**KIRKLEES METROPOLITAN COUNCIL
TOWN AND COUNTRY PLANNING ACT 1990
HIGHWAYS DEVELOPMENT CONTROL KP20H**

PLANNING REF 2016/62/93160/E0/ET
CATEGORY Minor

PROPOSAL ERECTION OF TWO SEMI
DETACHED DWELLINGS

LOCATION LAND ADJ 82 HEALEY LANE
HEALEY
BATLEY
WF17 7ST

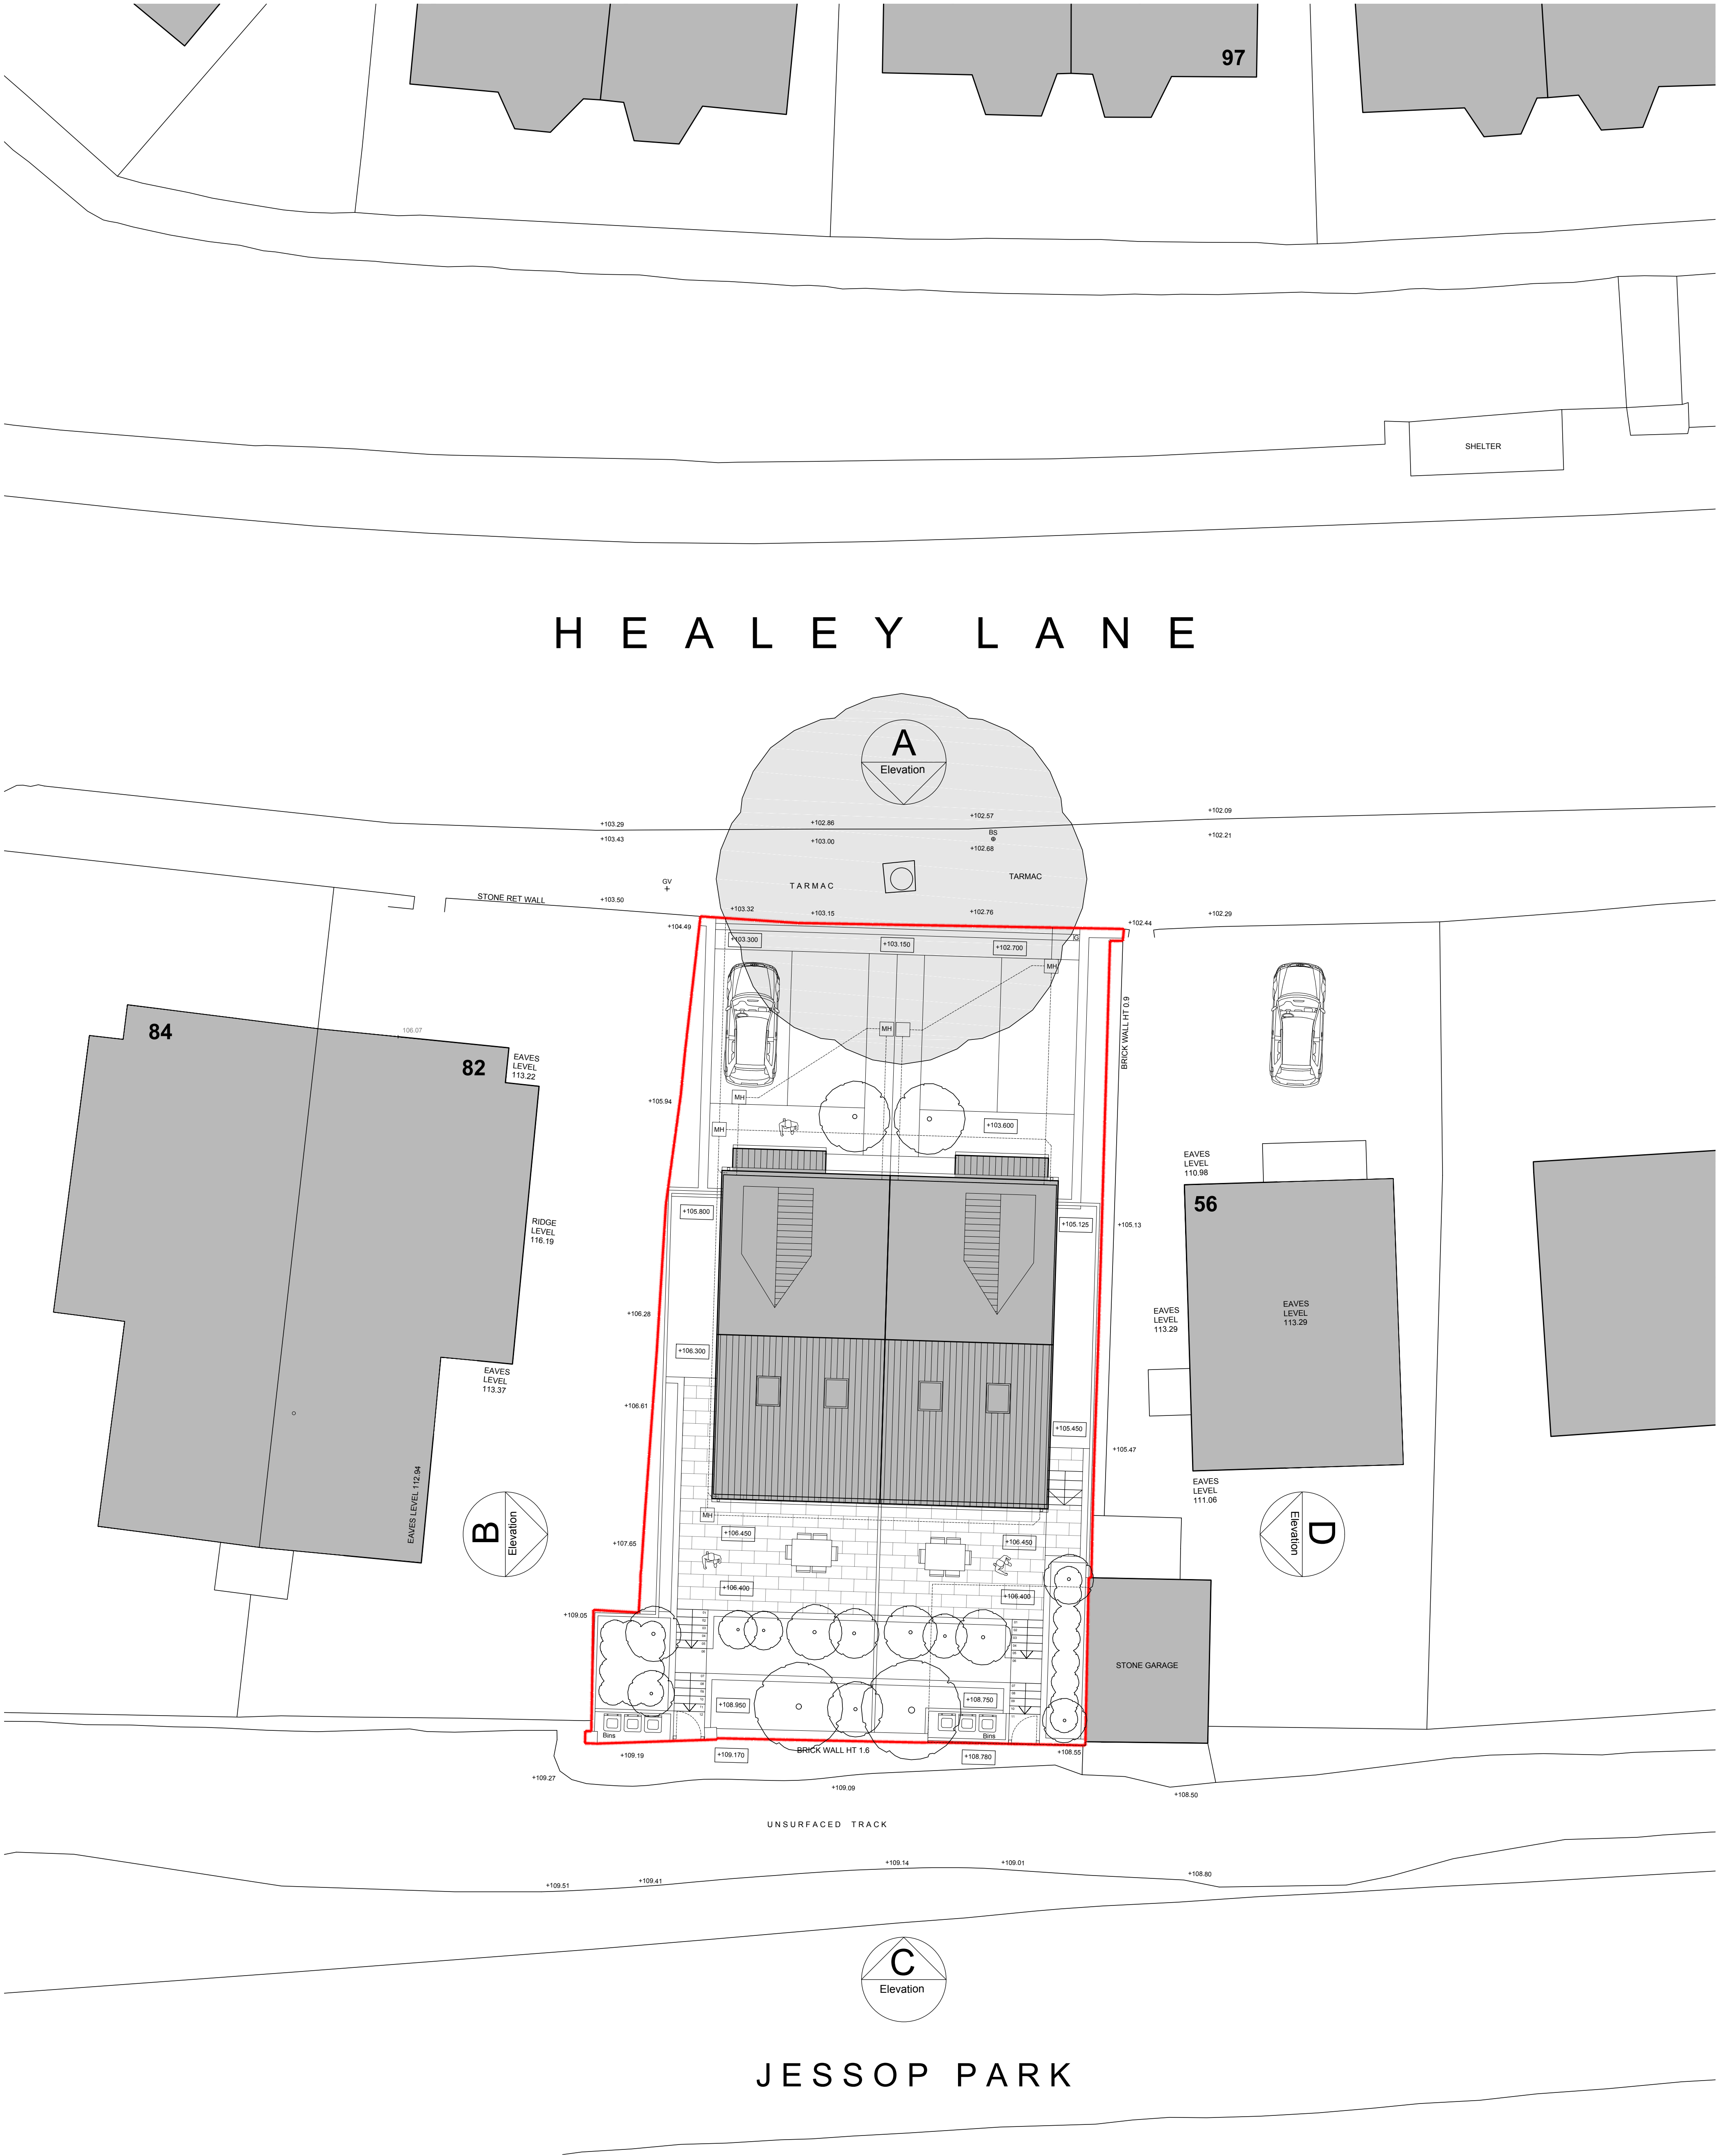
The proposed access to the site is obstructed by a bus stop and bin which would need relocating. Metro would need consulting regarding the relocation of the bus stop.

There is also a tree blocking the proposed access, this would need removing and both the relocation of the bus stop and removal of the tree needs to be indicated in the proposed site/ block layout.

Client Mrs Victoria Garland
Project 1589 - Healey Lane - Residential Development
Title Proposed Site Plan

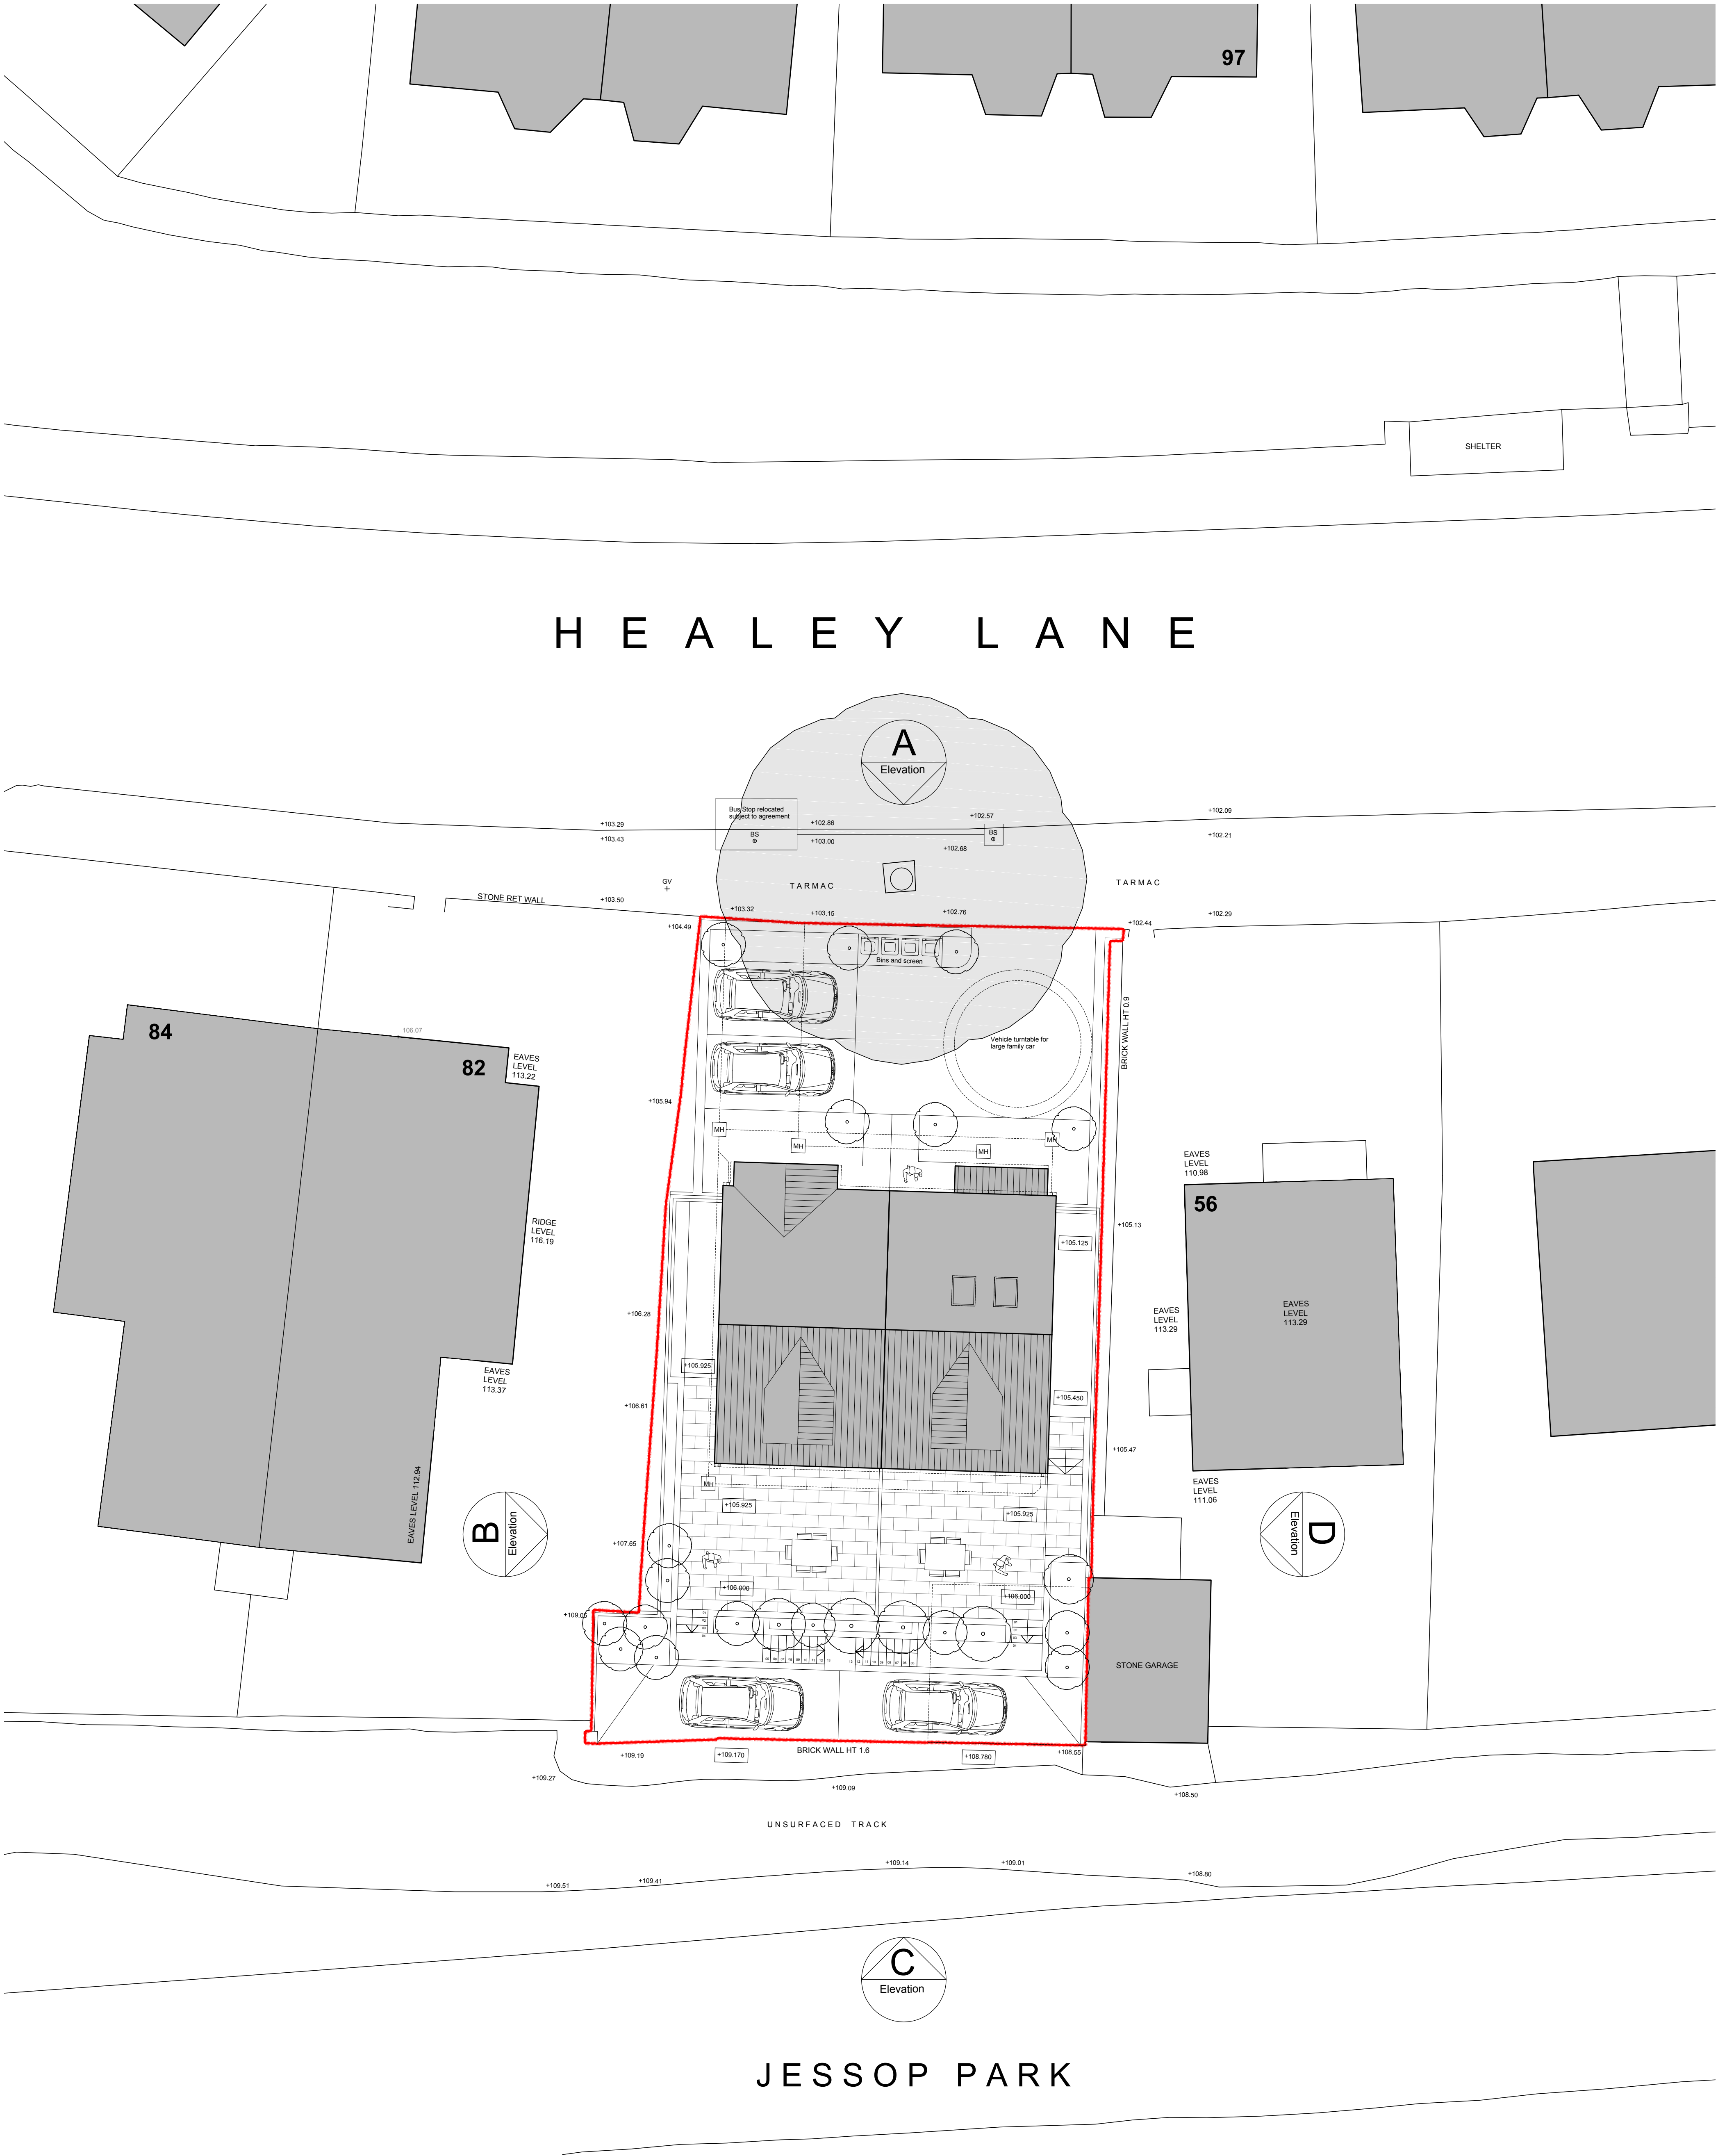
Healey lane is a classified road and internal turning should be provided to comply with recommended standards.

The proposed development is for 2 semi-detached dwellings both with 4 bedrooms and 2 proposed parking spaces for each dwelling, parking standards (UDP) state that a 4 or more bedroom property requires a minimum of 3 parking spaces.
